## **Appendix 7U**

**Response to LPA ecology  
chapter PAC comments**

| <b>Comment number</b> | <b>Category</b> | <b>LPA comments (including written response and those raised during meeting 17.11.2020)</b>  | <b>Arup response 3.2.2021</b>  |

Figure 1. The Masterplan

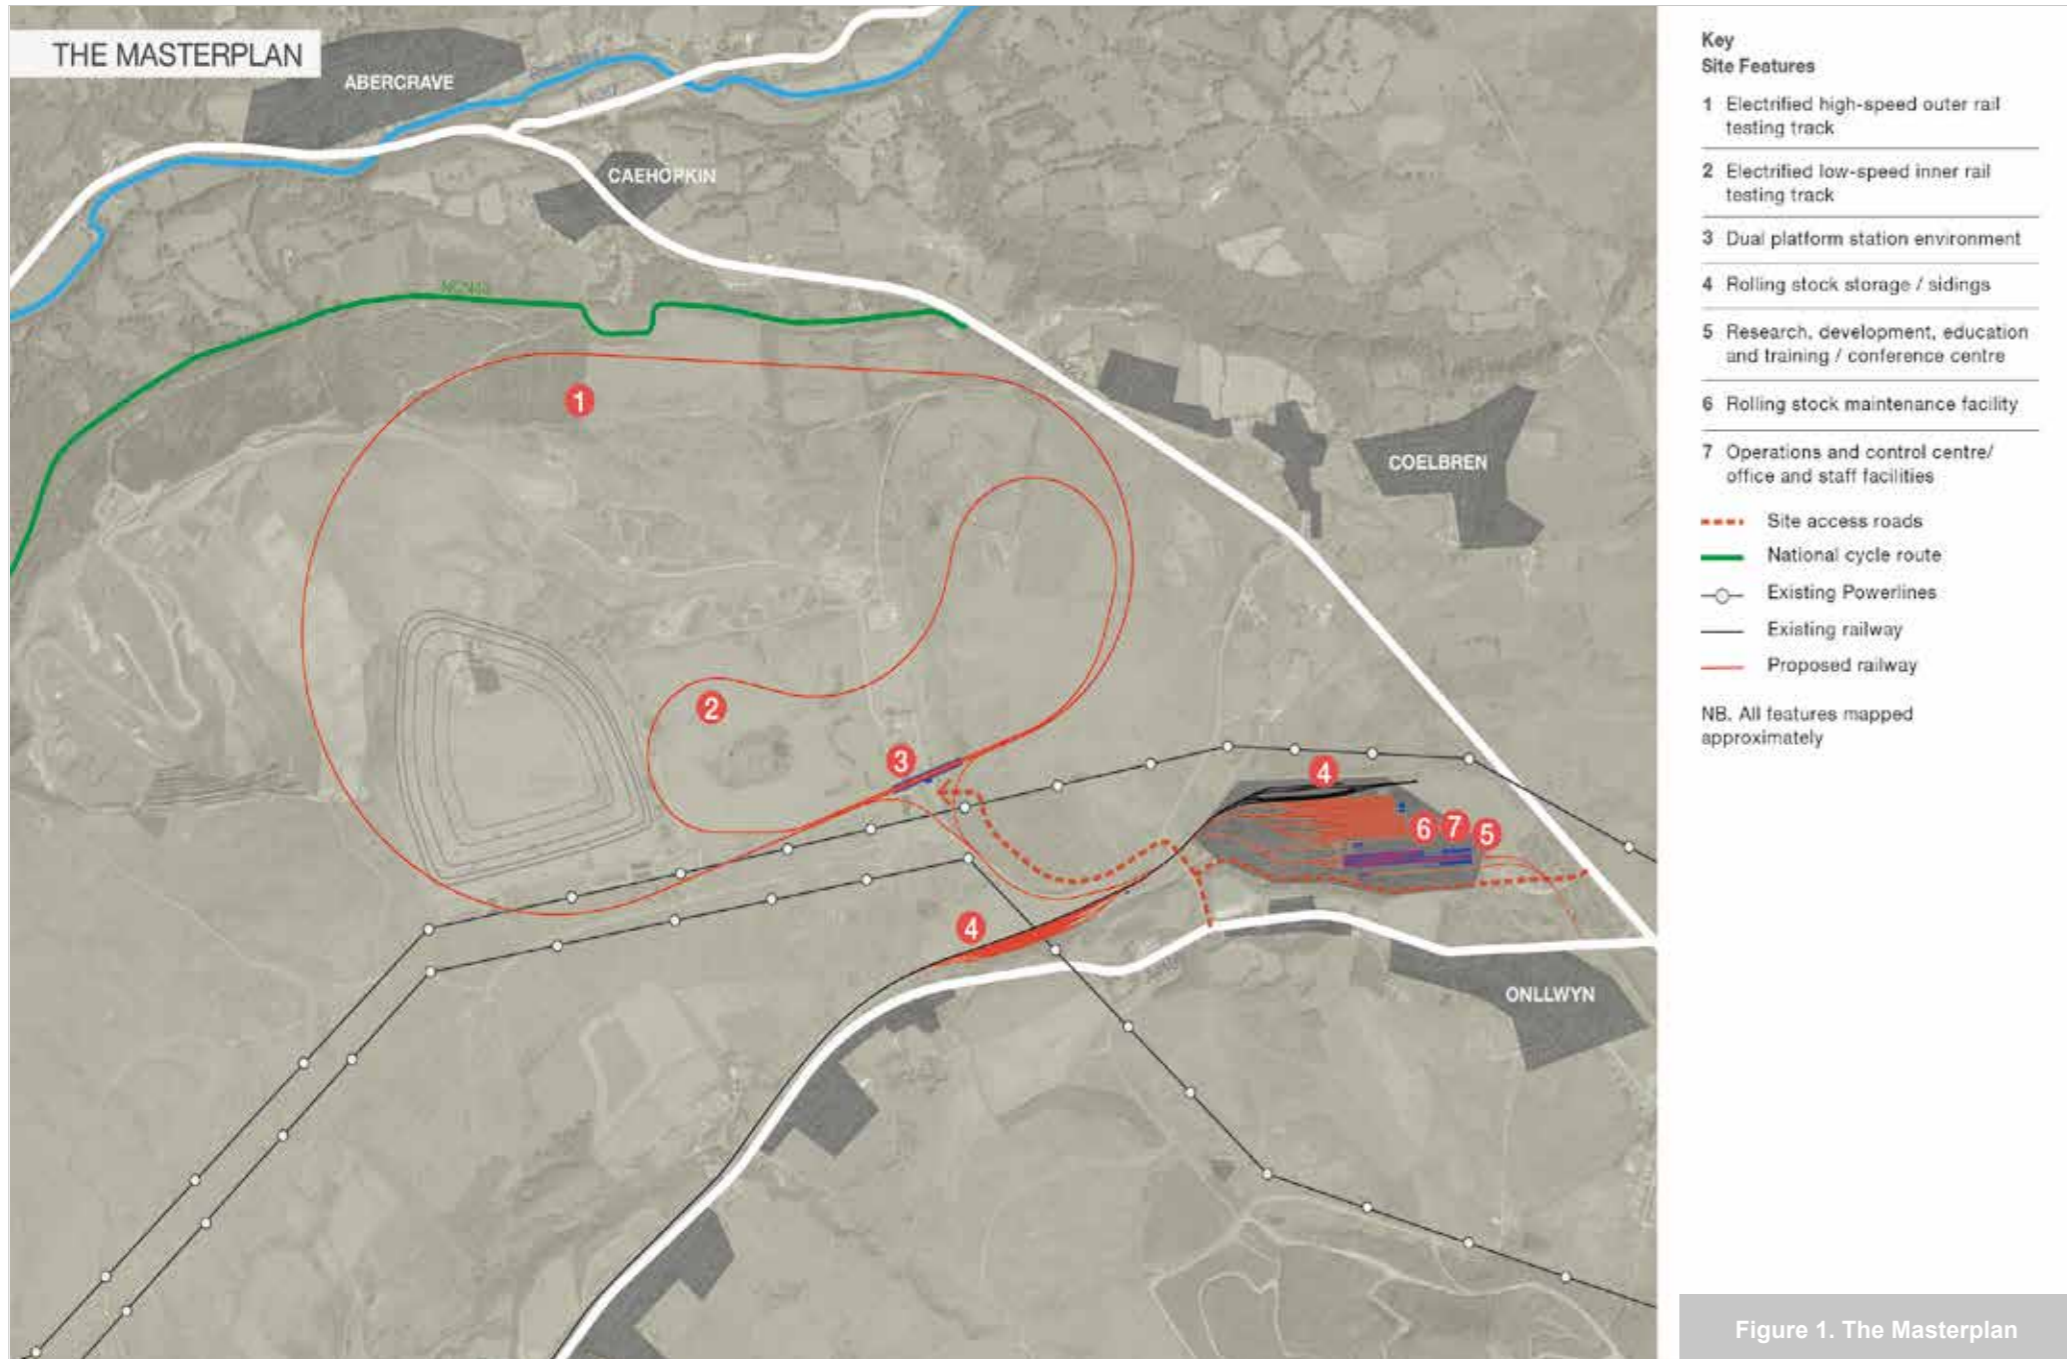
| <b>Comment number</b> | <b>Category</b>                                 | <b>LPA comments (including written response and those raised during meeting 17.11.2020)</b>  | <b>Arup response 3.2.2021</b>  |
|-----------------------|---|--|--|
| 16                    | Design  | The car park shown on the masterplan seems to be missing from the ecology plans in Vol 3. Clarification should be provided as to whether the car park location has been appropriately assessed.  | This has been added to the plans   |
